From: Sue Howell <Sue.Howell@arun.gov.uk>
Sent: 31 January 2022 08:33
To: Simon Davis <Simon.Davis@arun.gov.uk>
Subject: RE: Planning Consultation on: A/236/21/PL

The information submitted in the revised Landscape Proposals LSP/073/001 REV C dwg is generally suitable, but please ask the applicant to confirm the species and the height at time of planting of the three additional indicated trees.

Figure Number: LSP/073/001

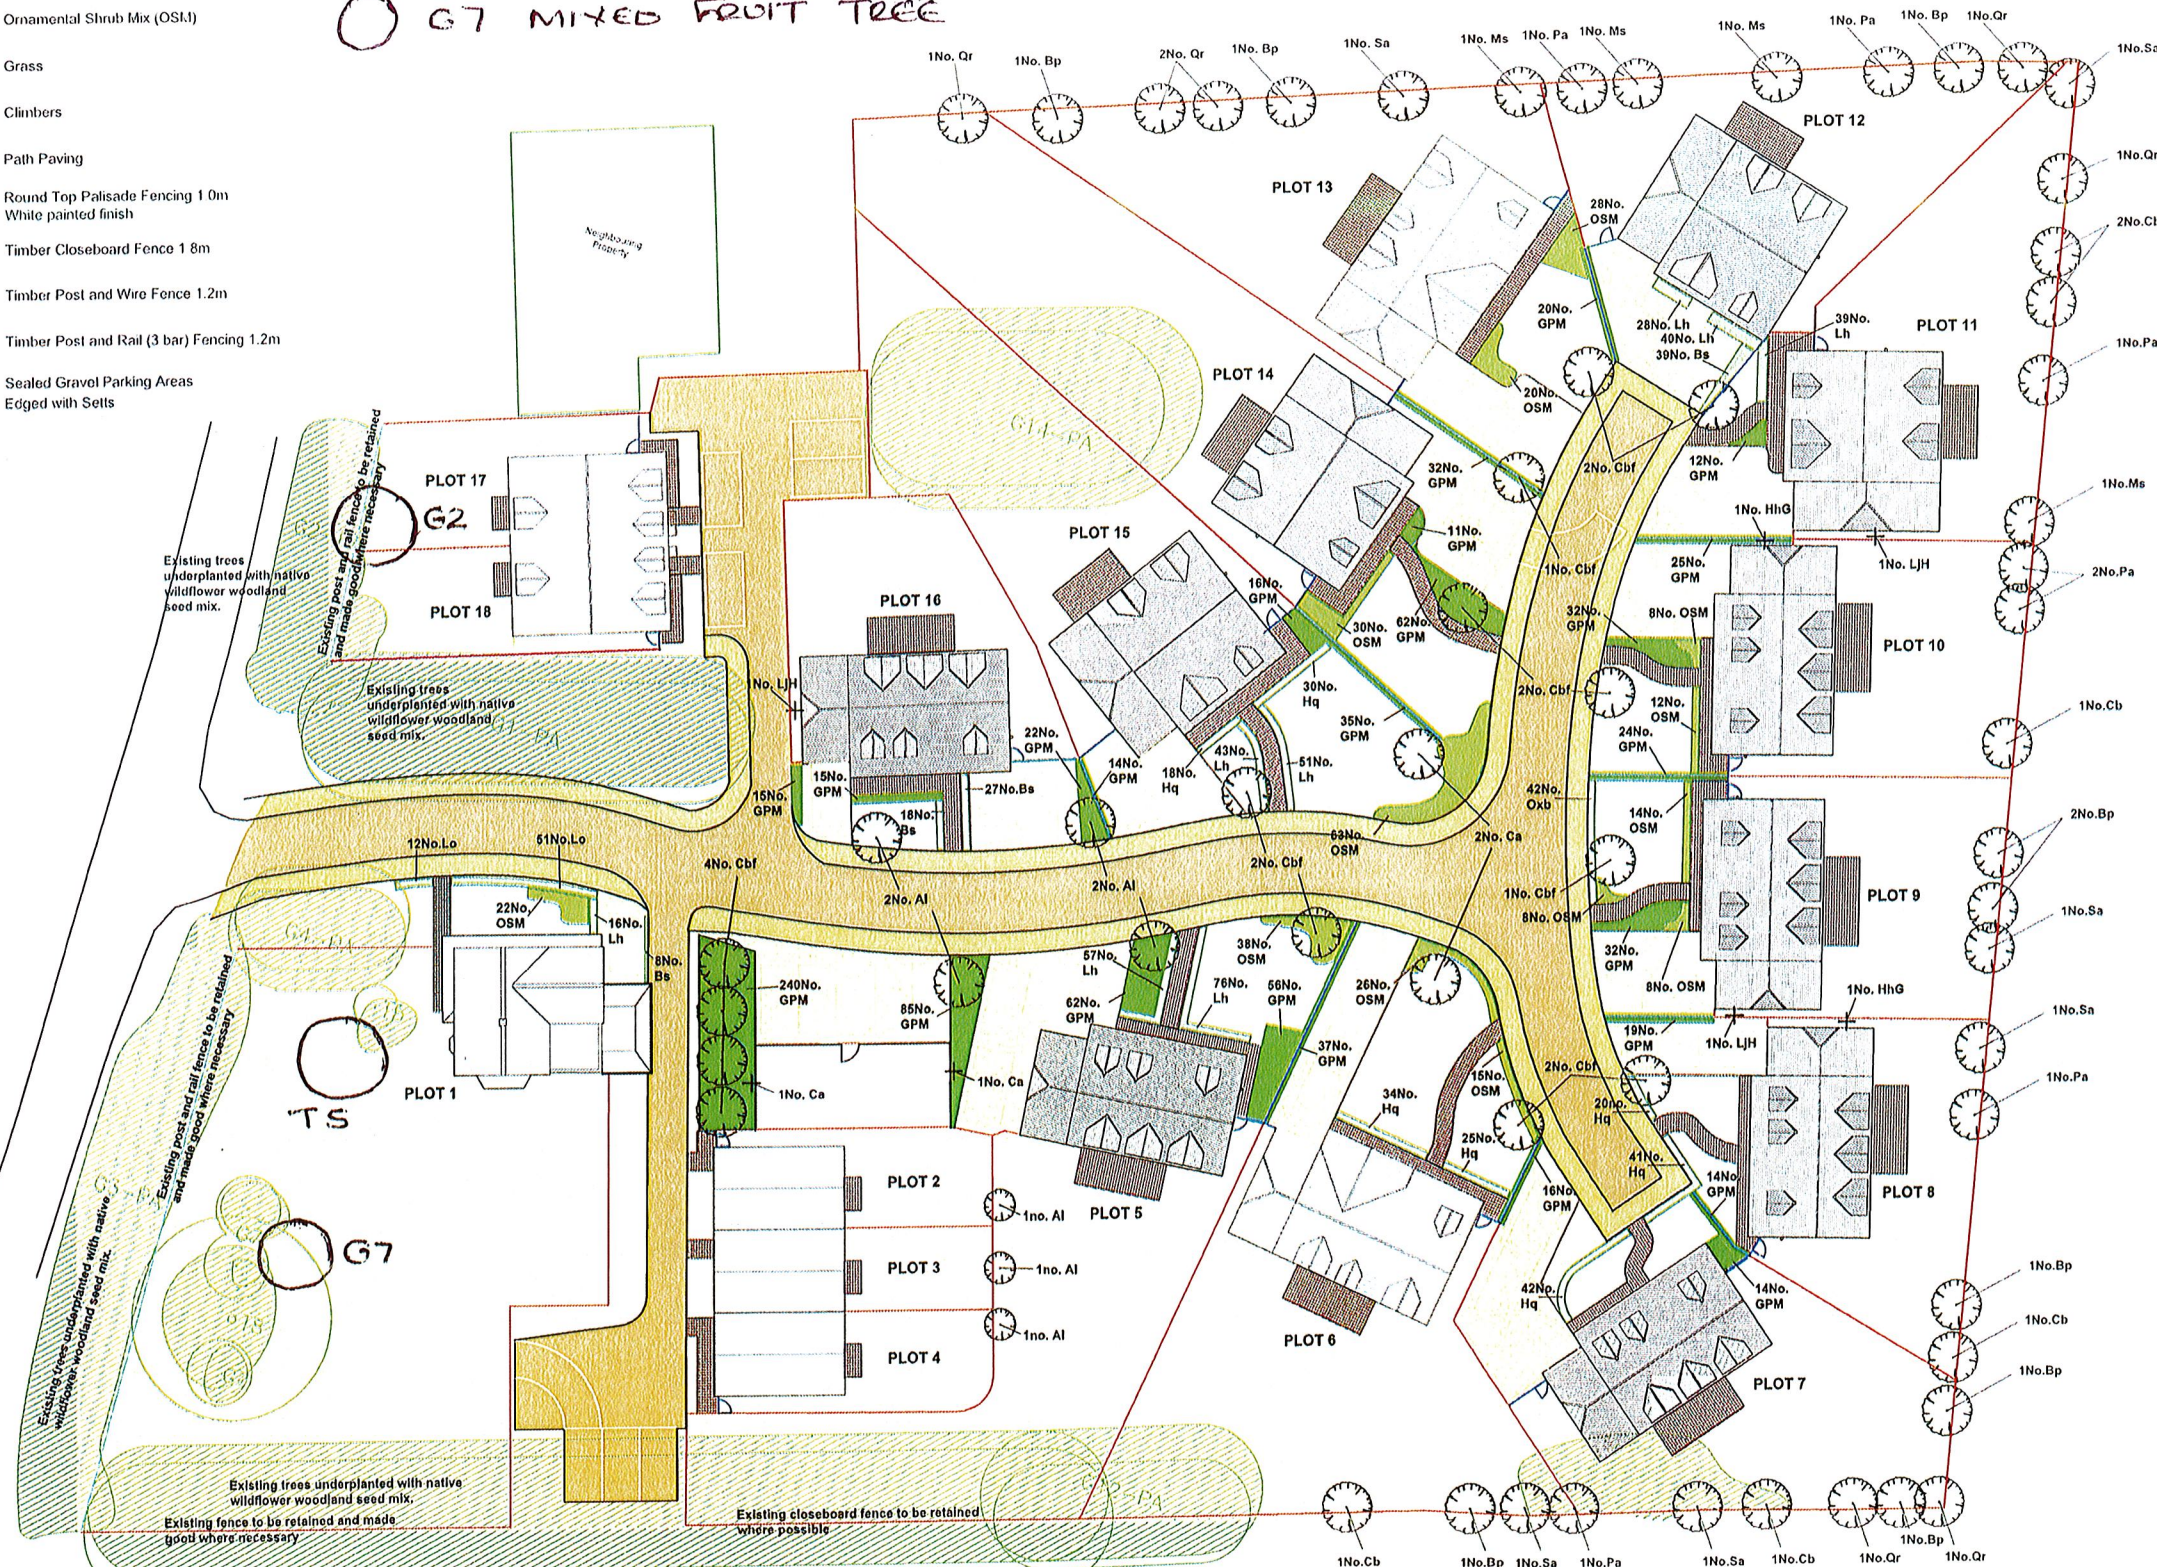
Ok that's fine we have species and height ... Elm must be disease resistant variety such as Ulmus New Horizon (or similar) fruit trees not so important re variety.

- G2 Tree – Elm with a height of approx. 5m
- T5 Tree – Magnolia with a height of approx.. 5-6m
- G7 Tree – mixed Fruity with a height of 5m
